Wal-Mart at Cutler

Administrative Amendment Request

Project #PR- 2021-005016

Transportation Development Comments:

Drawing file: Walmart-5430_Original_Submittal / 6002 - CS2 PROPOSED PICKUP DEMOLITION & SITE PLAN - 5430.pdf

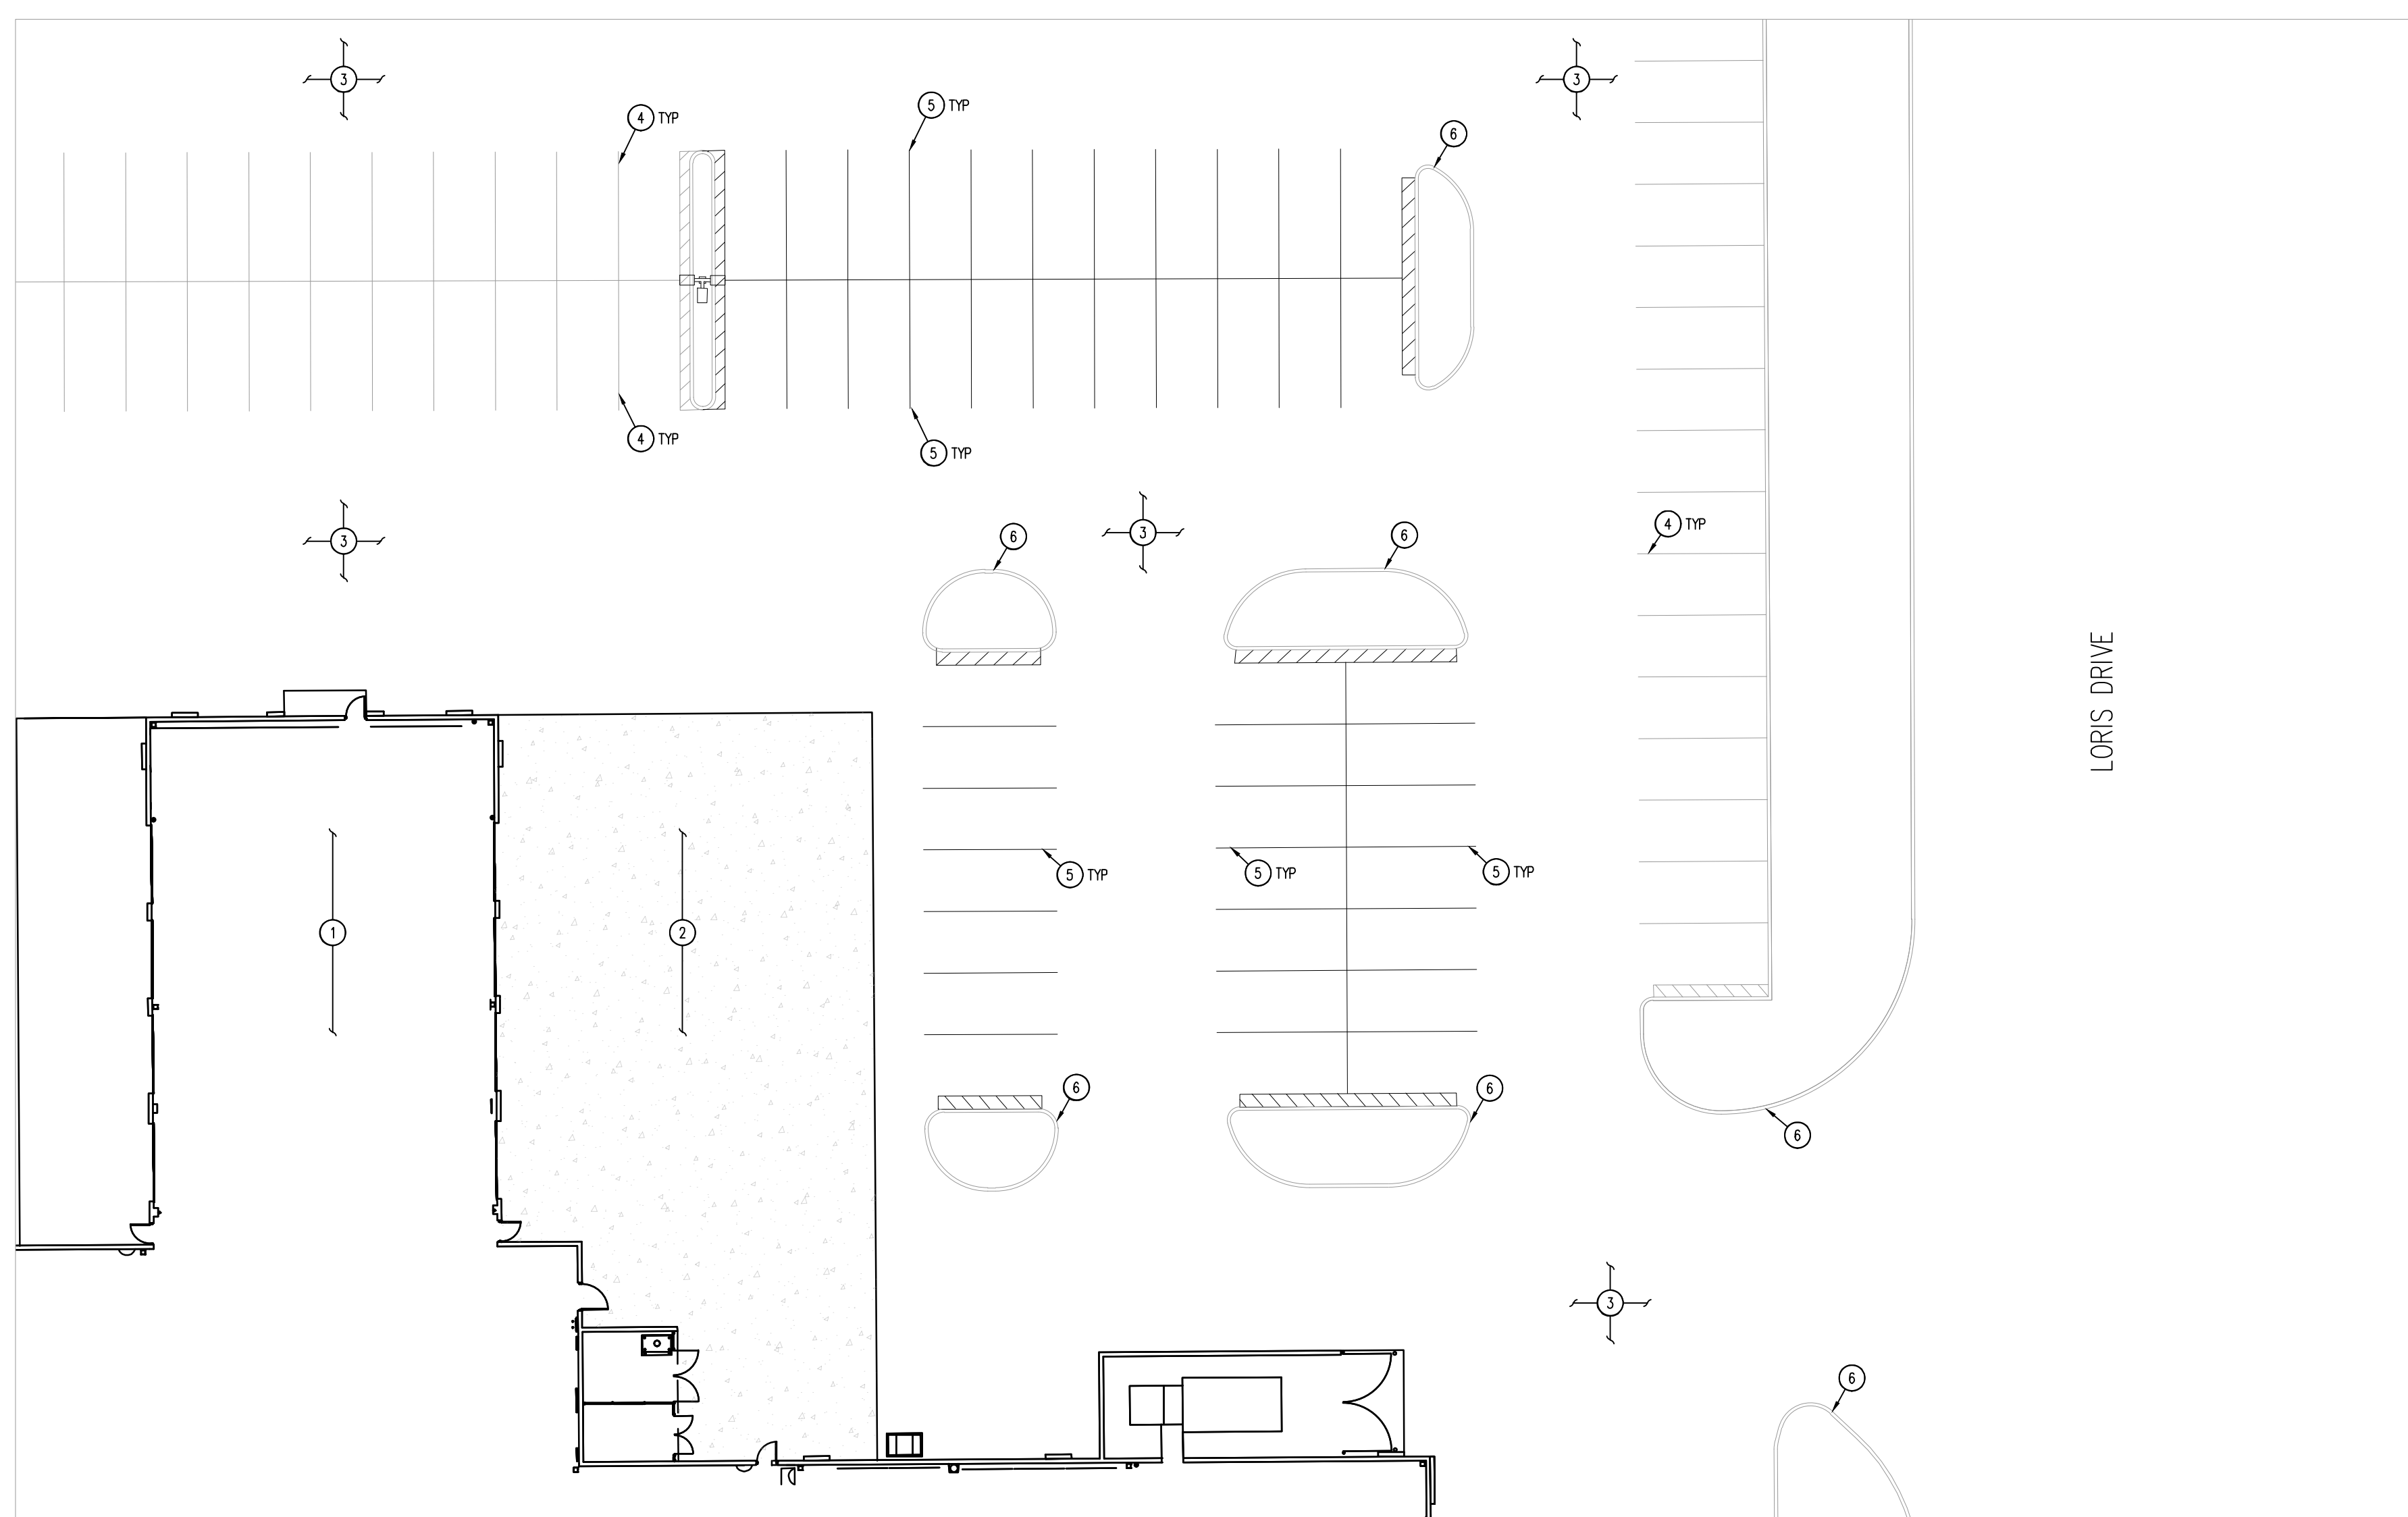
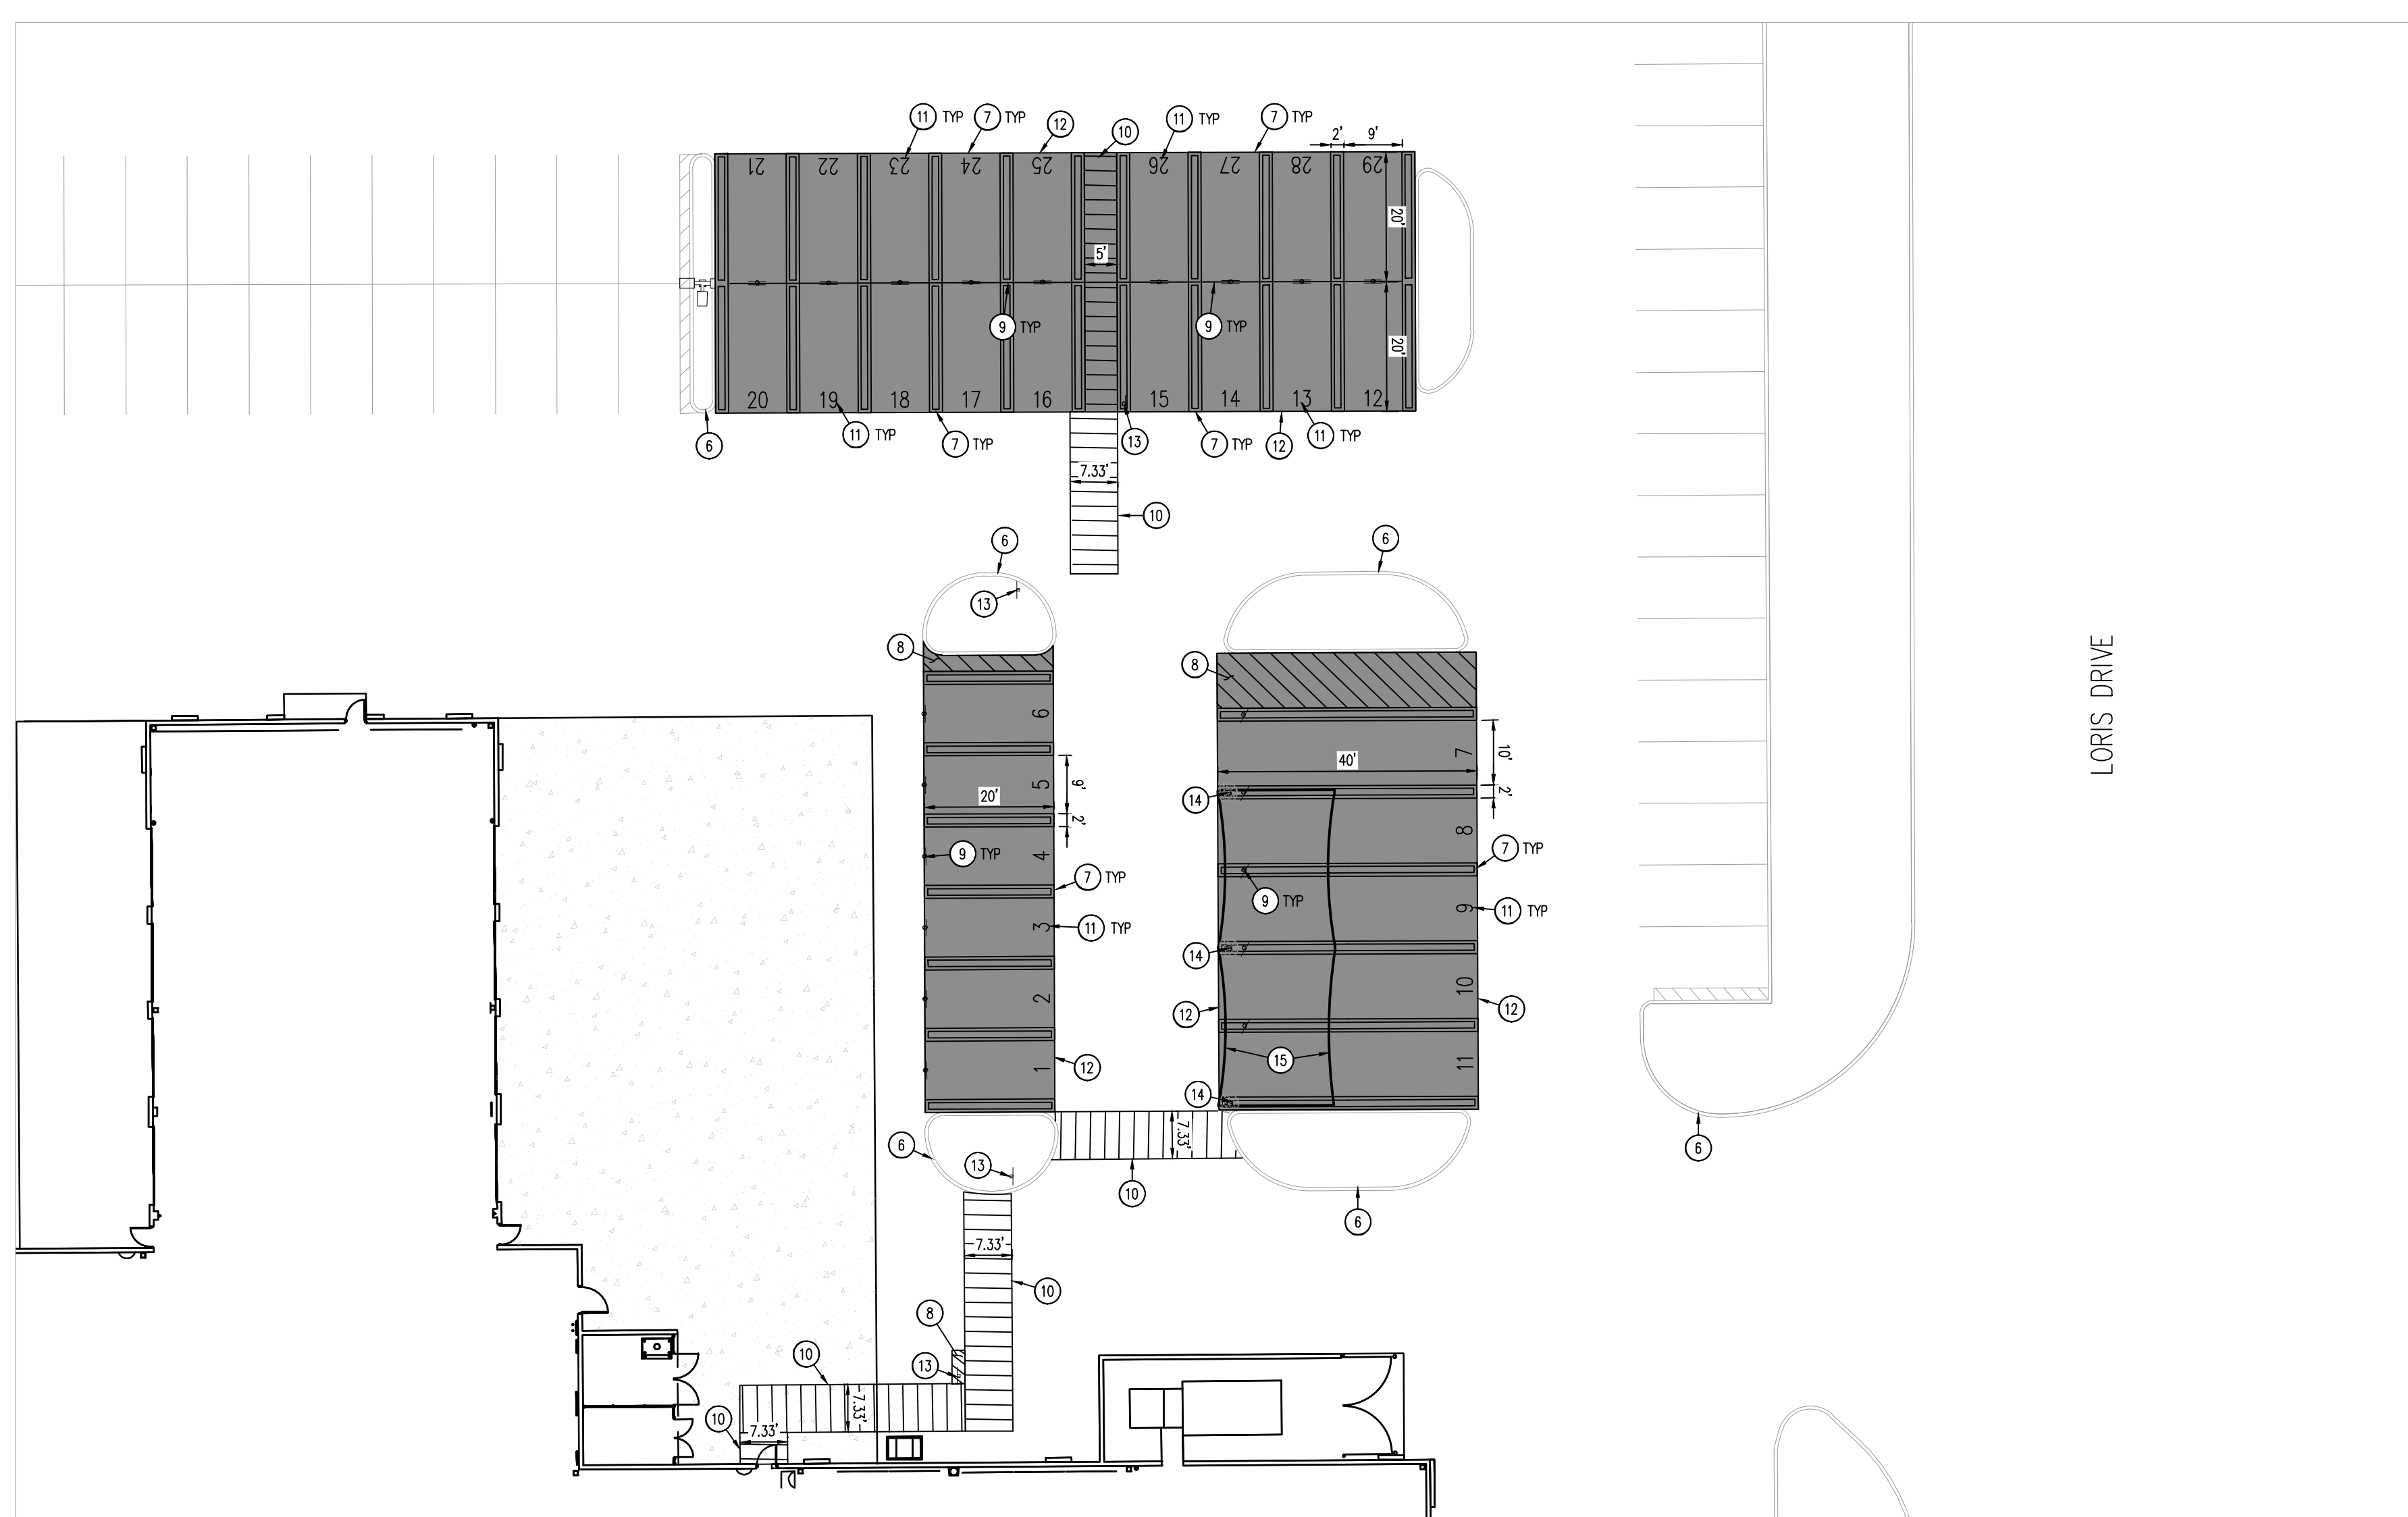
1. For centerline striping, the ratio of the gap to the stripe should be 3:1.
2. Provide "Yield to Pedestrian" signage on either side of the main crosswalk entrance per MUTCD requirements.
3. In the package, I did not see any details for signage and striping or a plan for parking spaces that involve pick-up only, similar to the other Wal-Mart packages. Please make sure to provide all plans.
4. Be sure to cross out keyed notes that are not used for this submittal. For any detail sheets provided, delete any signage that is not being used.
